River Bend Crossing
Traffic Impact and Access Analysis
PCD File No. P189, SP187, SF1844, & SF1843
(LSC #184140)
September 9, 2019

Engineering Review

Figure 2
Site Plan

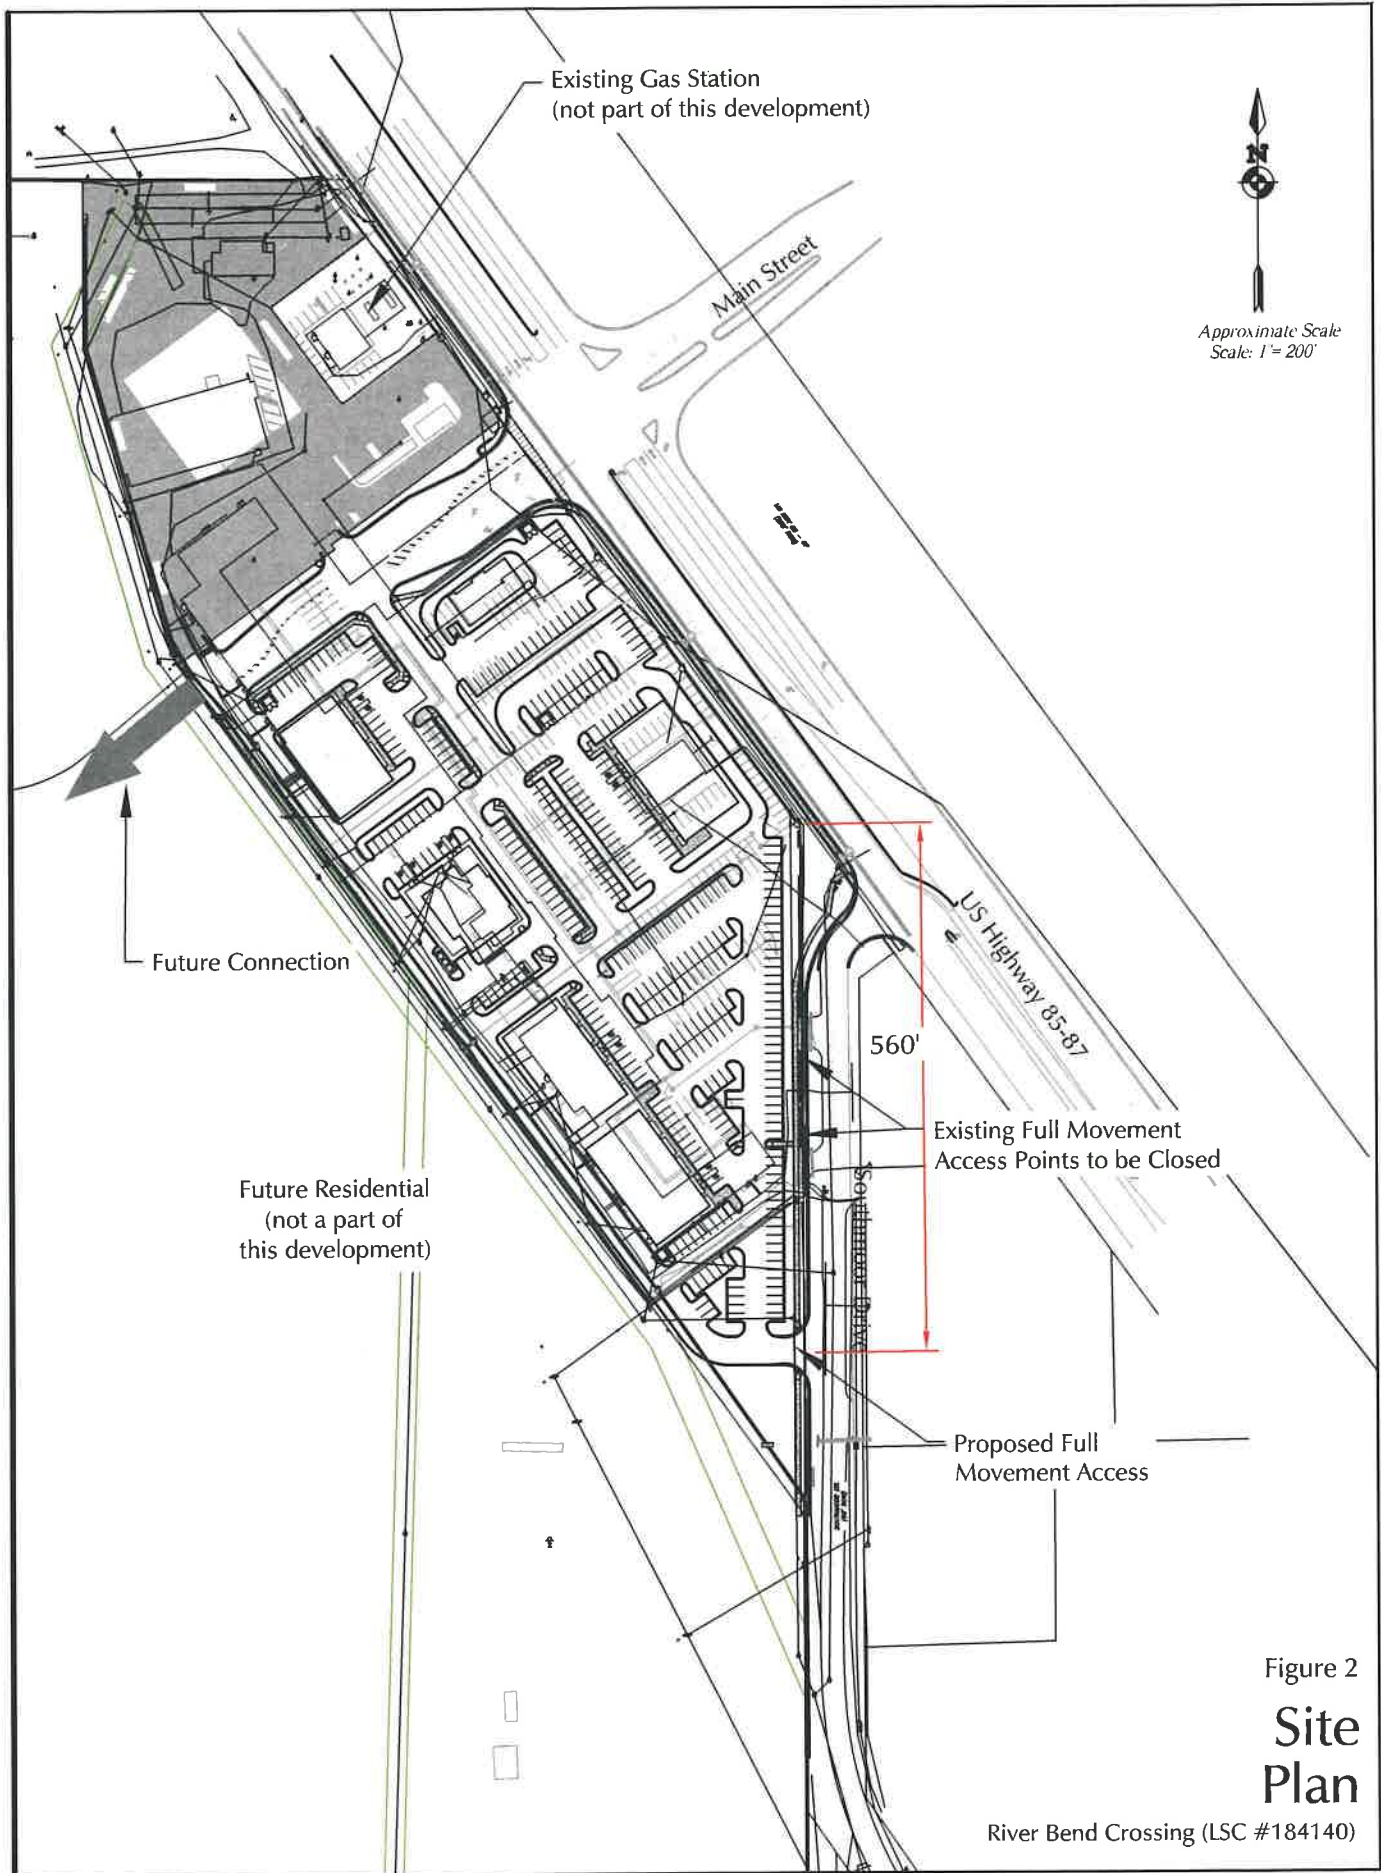
Show latest site plan and accesses on east side. Label distances between all existing and proposed access points.

Figure 13
**Proposed Main
 Access Lanage**
 River Bend Crossing (LSC #184740)

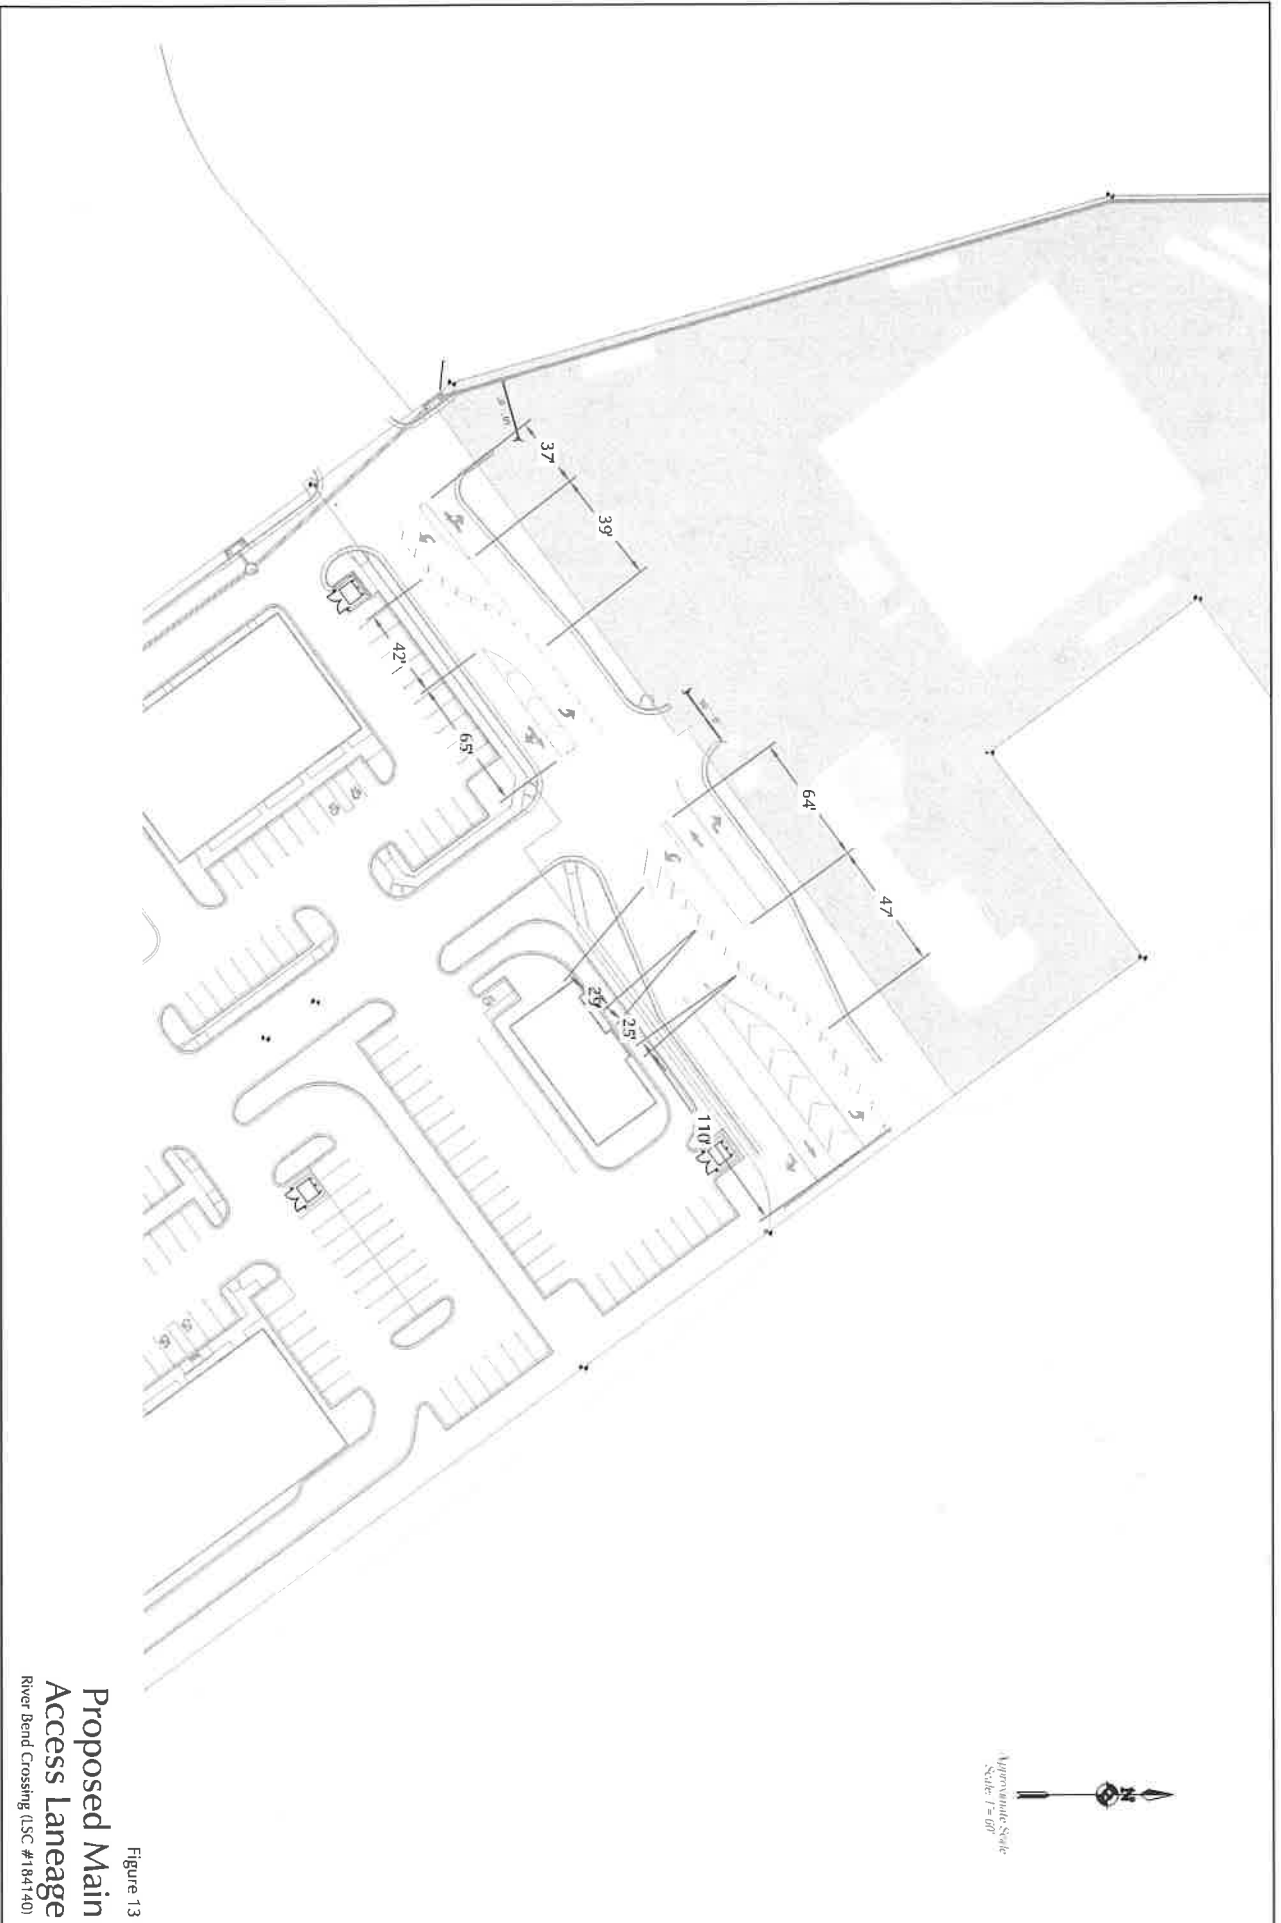
Provide proposed cross-sections for Southmoor Dr. - interim and ultimate.
